## Application for Removal or Variation of a Condition following Grant of Planning Permission or Listed Building Consent

Construction of hard standing in connection with vehicular access

22/04259/FUL

2

Title:  
Site Plan as  
Existing and Proposed

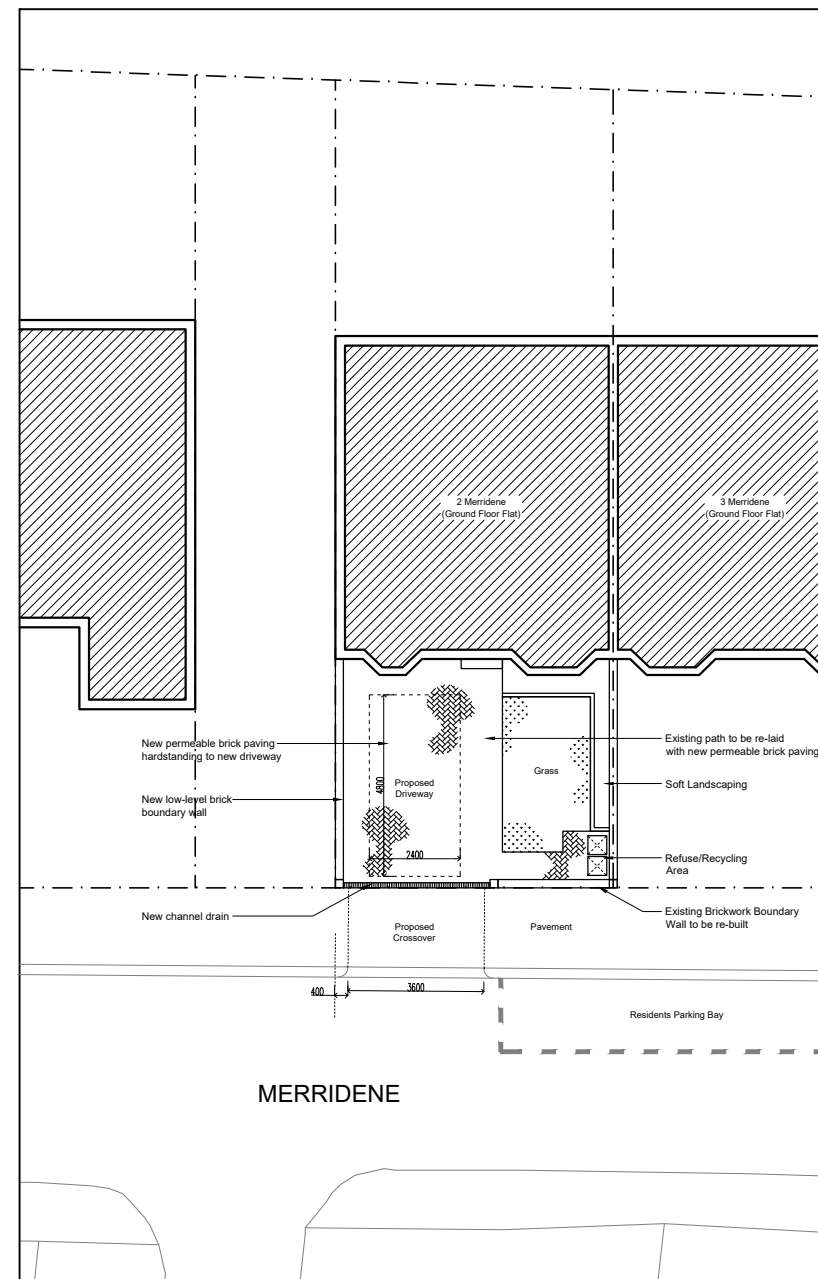
We would like to request a larger crossover. The approved crossover is 3m wide, however we would like to request a 3.6m wide crossover so as to provide better vehicular access for the applicant.

We would like to increase the approved crossover from 3m to 3.6m so as to provide better vehicular access for the disabled applicant.

336 - 03\_B Site Plan as Existing and Proposed
